**Application by London Resort Company Holdings for an Order
granting Development Consent for the London Resort**

Planning Inspectorate Reference: BC080001

RELEVANT REPRESENTATION
BY PORT OF TILBURY LONDON LIMITED (POTLL)

31 March 2021

Figure 3: Essex Marine Site.

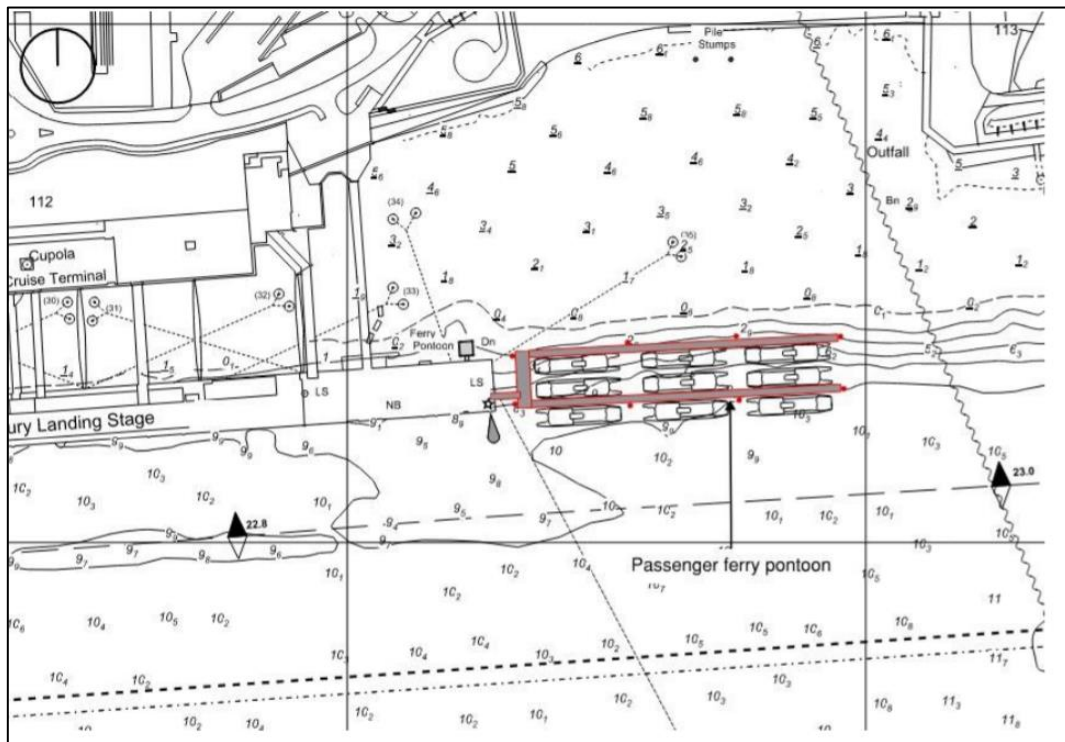
- 4.2.2 the suggested design for the landing stage shown at Figure 2-4, and the content overall (including the risk assessment methodology) of the Preliminary Navigation Risk Assessment [APP-135], is not yet agreed by PoTLL. In particular, the current U shaped suggestion is considered unworkable by PoTLL and the PLA. However, PoTLL notes and
